ENG-SF22023-R1-GEC.pdf Markup Summary

DSP-20-005 (FALCON MEADOWS AT BENT
-22-XXX (FALCON MEADOWS AT BENT GRP

Engineering Review
08/19/2022 2:51:35 PM
dsdrice
JustRice@delaware.com
(719) 520-7877
EPC Planning & Community
Development Department

**GRADING & EROSION
CONTROL INTERIM PLAN**

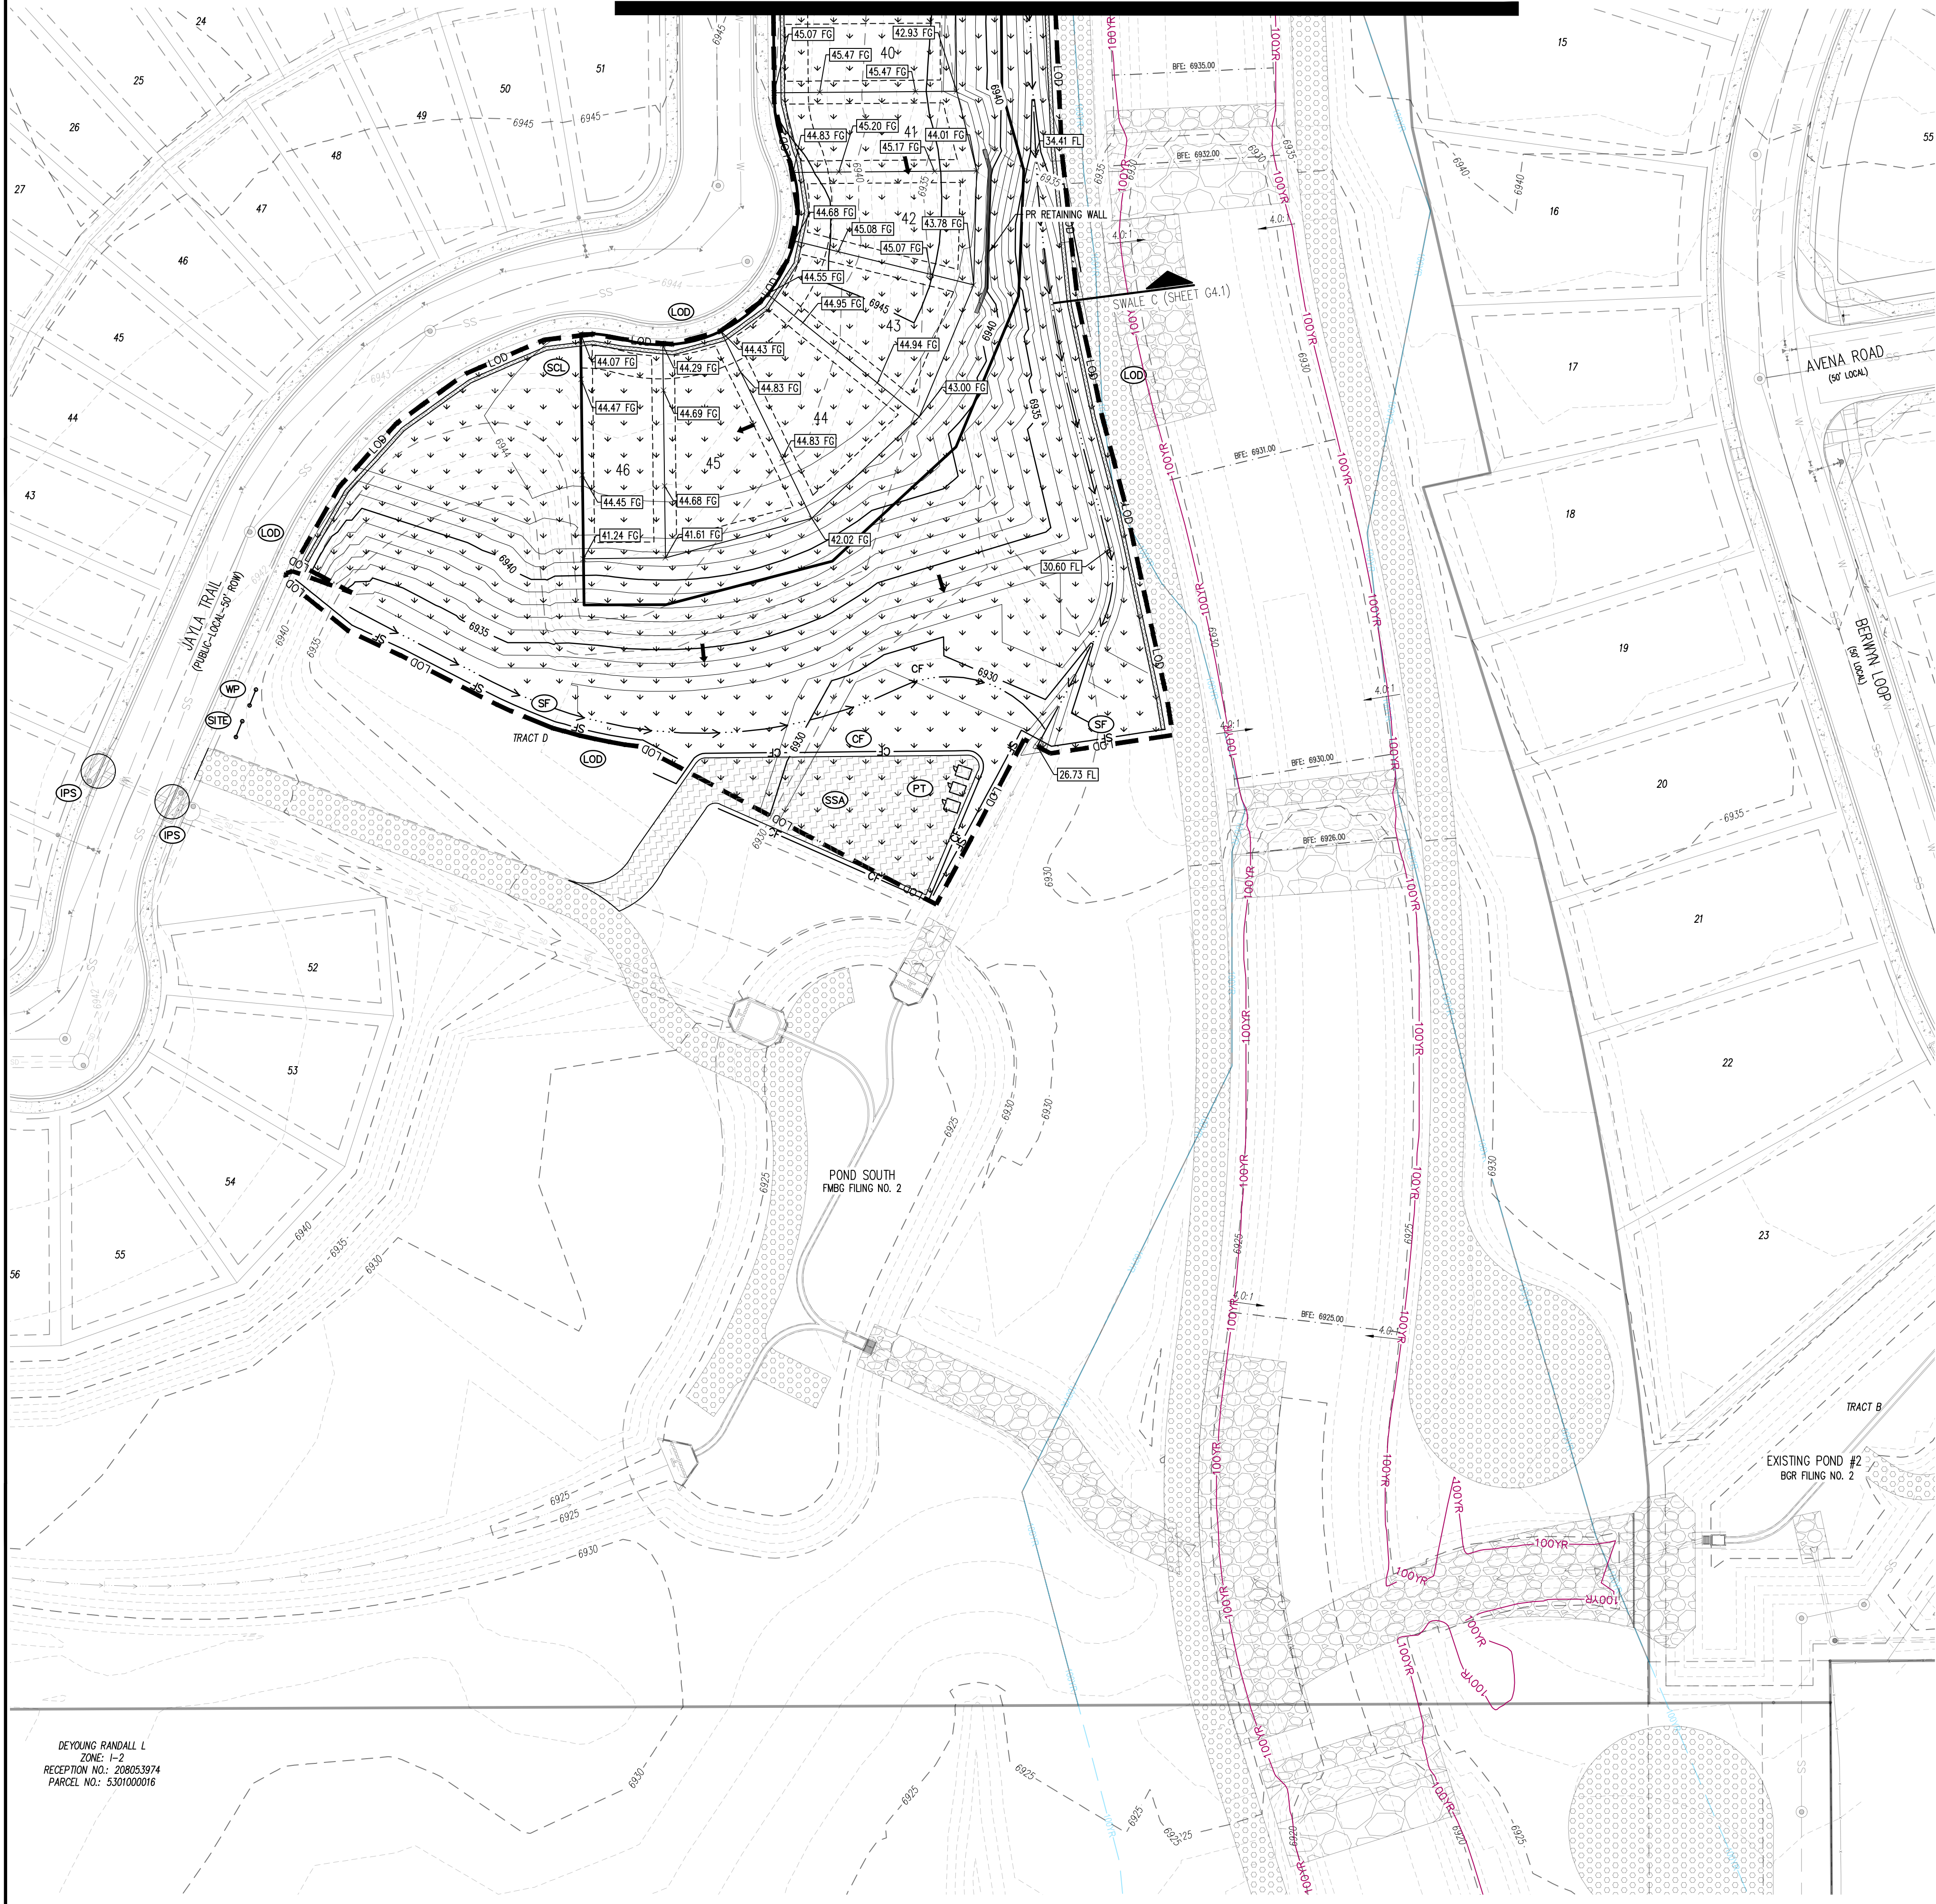
Maint trail access?

I'm not seeing this linetype anywhere on these plans. Per GEC Checklist item "p," please add it in.

Is the intention for this straw wattle to go in as an initial BMP prior to the beginning of grading (ie: prior to the construction of the swale)? Because once the swale is constructed (interim condition), this wattle shouldn't be shown down the flowline of the swale. So maybe bump the wattle out closer towards the LOD? And then in the interim condition you'll need some form of CD's across (perpendicular) to the swale flowline.
